**From:** William Clark  
**To:** Helen Donaldson  
**CC:** David Margolis-Pineo  
**Date:** 7/24/2015 3:41 PM  
**Subject:** 72 Bishop Street Survey Plan  
**Attachments:** Bishop St No 72 Boundary and Topo Survey Rev 6 23 2015 Survey Review 7 22 2015.PDF

I received notice that it was approved, subject to revision approval. I looked on Eplan and reviewed the 6/23/15 boundary and topographic survey. My review is attached.

REV. 2	06/23/15	ADJUST ELEVATIONS, ADDITIONAL LOCATION
REV. 1	01/20/15	ADDITIONAL LOCATION / TOPOGRAPHY
<b>BOUNDARY &amp; TOPOGRAPHIC SURVEY</b>		
AT 72 BISHOP STREET, PORTLAND, MAINE MADE FOR <b>AVESTA HOUSING</b> 307 CUMBERLAND AVENUE, PORTLAND, MAINE		
<b>OWEN HASKELL, INC.</b> 390 U.S. ROUTE ONE, FALMOUTH, ME 04105 (207) 774-0424 PROFESSIONAL LAND SURVEYORS		
Drwn By	JCS	Date
Trace By	JLW	JULY 17, 2014
Check By	JCS	Scale
Book No.	1125	1" = 30'
Job No.	2014-031P	Drwg. No.
		1

SURVEY REVIEW 7/22/15

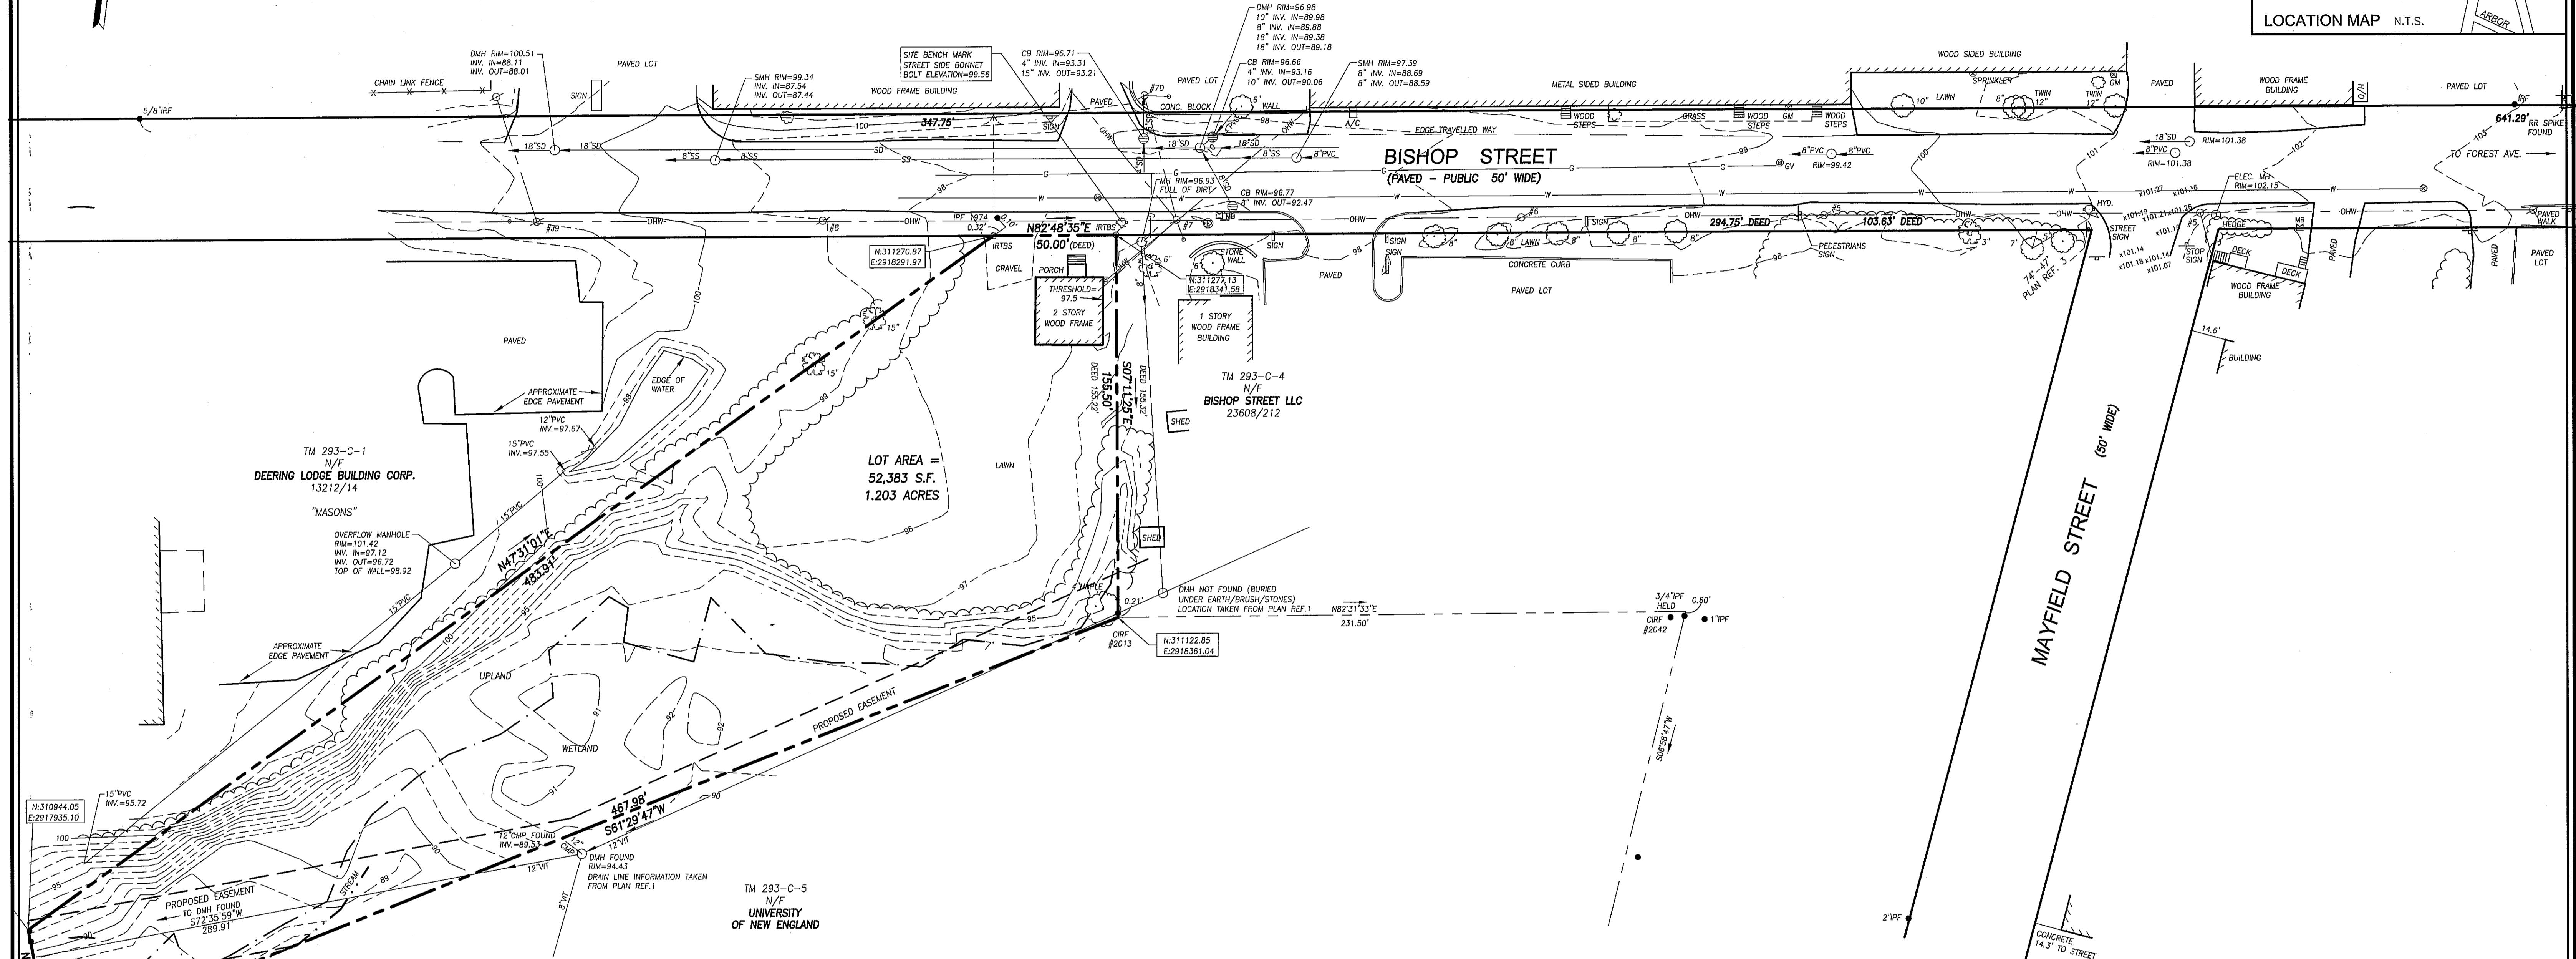
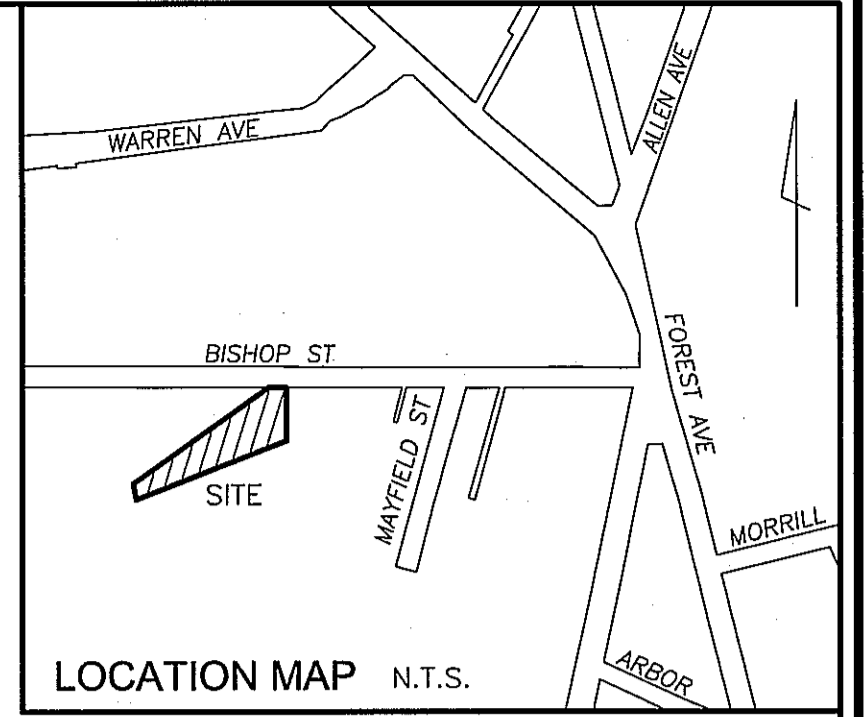
1. Label the proposed easement as "Proposed Easement" as "Proposed 30 foot Drainage Easement to City of Portland".
2. Add bearings and distances around the Proposed 30 Foot Drainage Easement as it affects the 72 Bishop Street property.
3. Show both sides of the Proposed 30 Foot Drainage Easement.
4. Storm drain pipe 15 feet easterly of 72 Bishop Street house. If it is abandoned we will not need to create a 30 foot wide drainage easement down to the buried drain manhole.
5. Note 4 stated that the City GIS shows a sewer line crossing the property. There is a sewer line farther down Bishop Street and there is no sewer line in the GIS crossing 72 Bishop Street.
6. On the Survey Review of 6/01/2015 it was noted that Bob Metcalf was provided with 5 DPW Engineering Plans (798/1, 431/30, 247/10, 484/7 & 387/75). Were they utilized to create the Proposed 30 Foot Drainage Easement?

The final amended subdivision plat will need to show the drainage easement information noted above.
